WEST SUSSEX COUNTY COUNCIL CONSULTATION

TO:	Arun District Council FAO: Kathryn Welch
FROM:	WSCC - Highways Authority
DATE:	18 October 2021
LOCATION:	215 Timberleys, Littlehampton, BN17 6QD
SUBJECT:	LU/266/21/PL Erection of 1 No. 4 bed dwelling (resubmission of LU/350/20/PL). This application is in CIL Zone 4 and is CIL Liable as new dwelling.
DATE OF SITE VISIT:	N/A
RECOMMENDATION:	Advice
S106 CONTRIBUTION TOTAL:	N/A

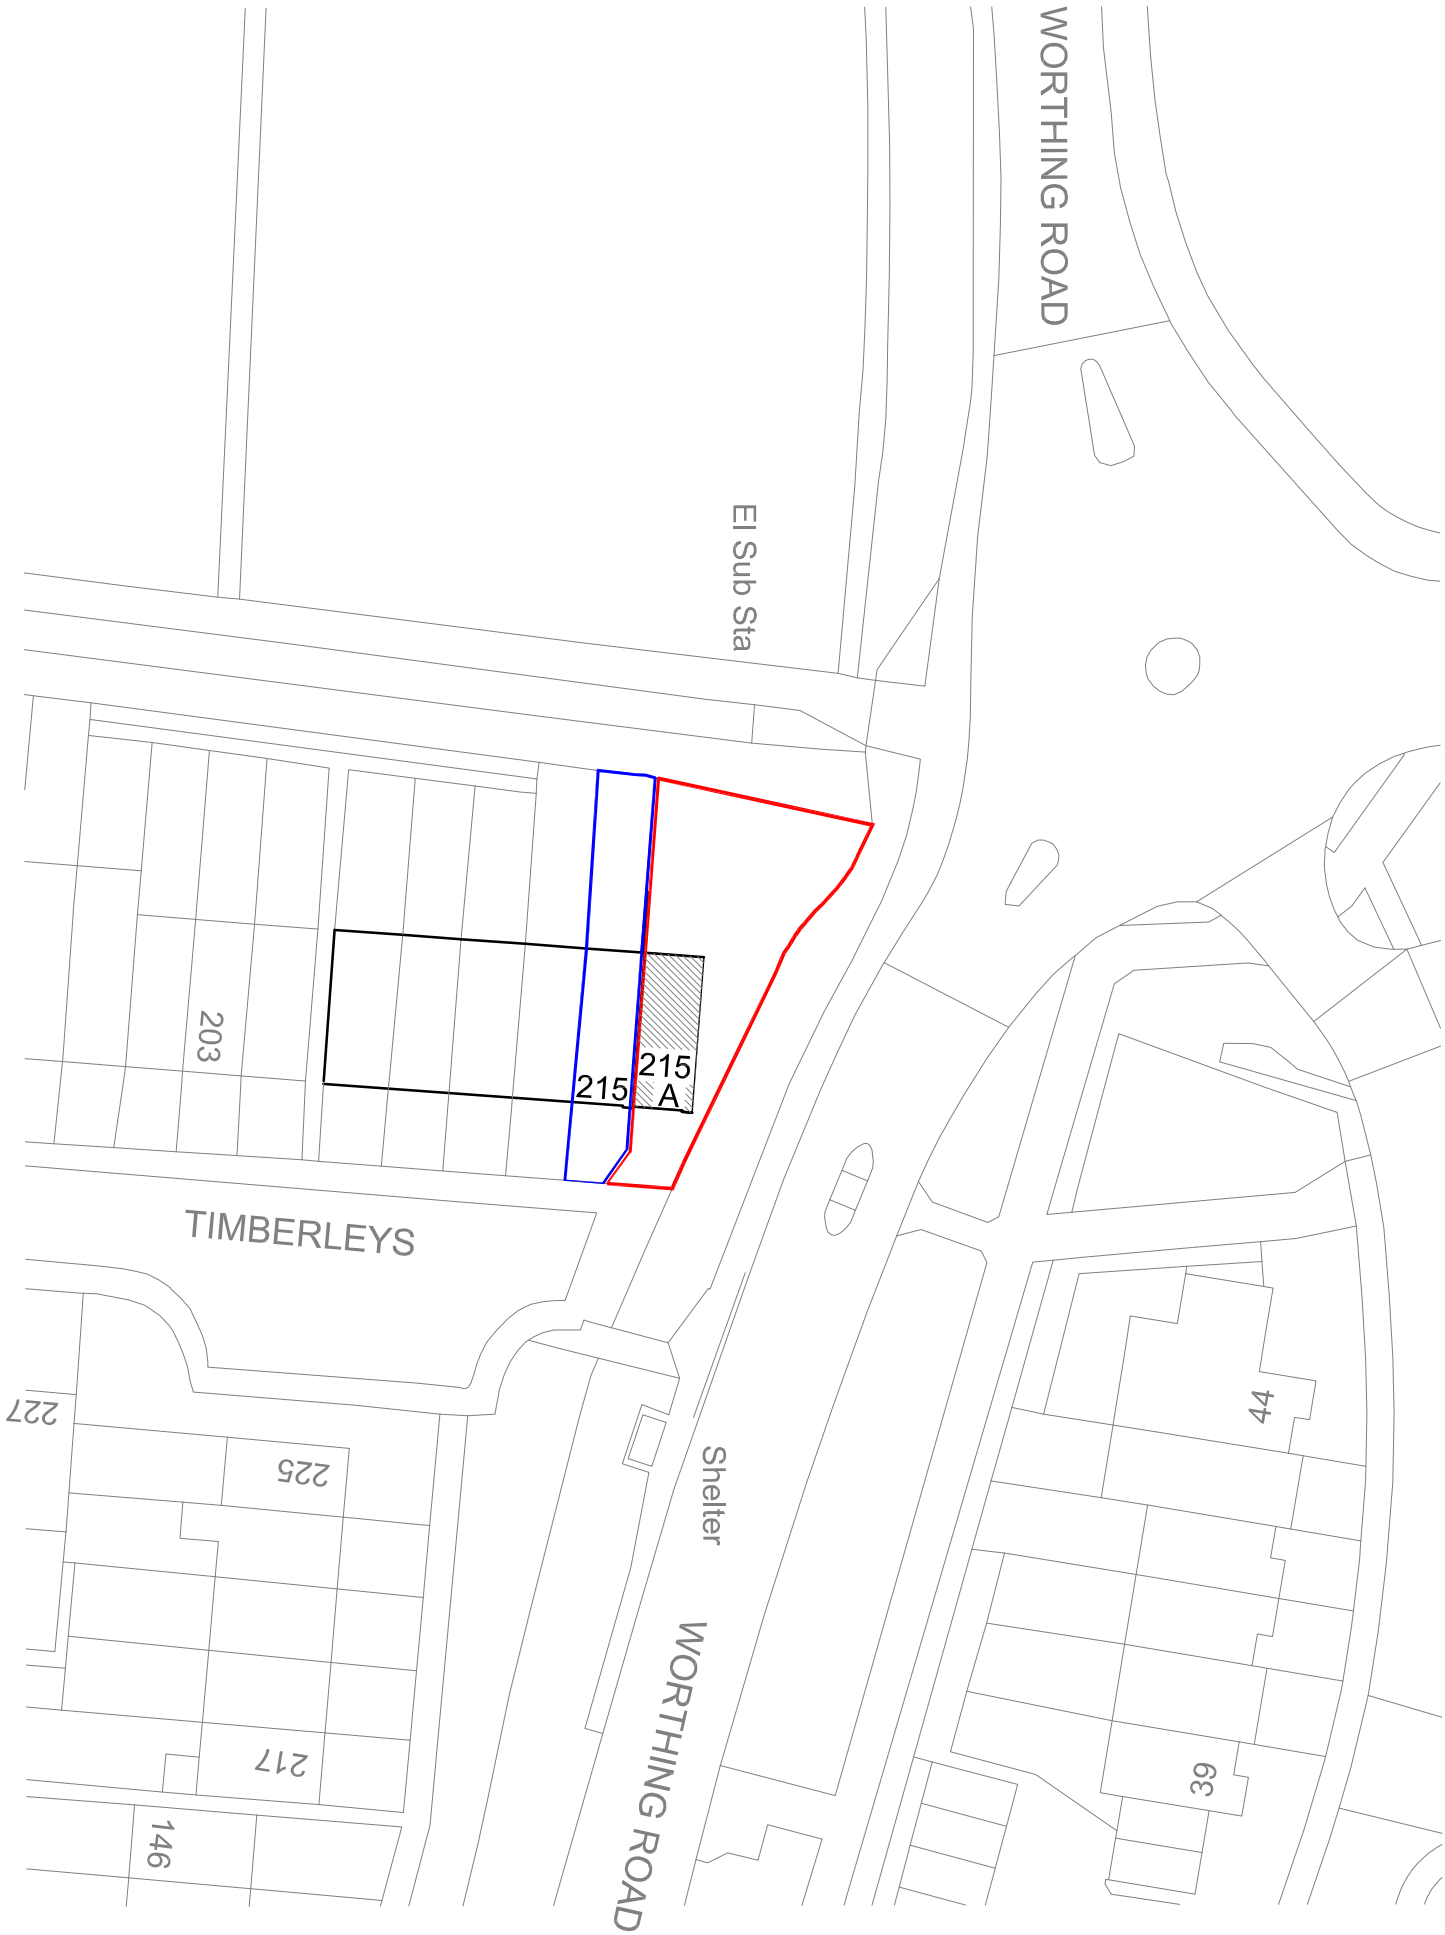
The applicant proposes a widening of an existing dropped kerb access, to form a driveway fronting the proposed dwelling. The proposed access works will be subject to a licence obtained through the local area office and constructed to a specification agreed with the local area engineer.

The applicant proposes one car parking space for this development. On-site turning does not appear achievable, so cars exiting the site may have to do so in a reverse gear. However, this is not anticipated to result in a highway safety concern.

Under Arun Parking Standards, the LHA would expect a parking provision of at least three parking spaces for a dwelling of this size in this location. Consequently, any overspill parking would have to be accommodated on-street.

Whilst not demonstrated in the plans, the Application Form states that two cycle parking spaces are proposed, in accordance with Arun Parking Standards. The applicant should demonstrate cycle parking in the form of covered and lockable cycle storage.

No part of the development shall be first occupied until the car parking has been constructed in accordance with the approved site plan. These spaces shall thereafter be retained at all times for their designated purpose.

No part of the development shall be first occupied until covered and secure cycle parking spaces have been provided in accordance with plans and details to be submitted to and approved by the Local Planning Authority.
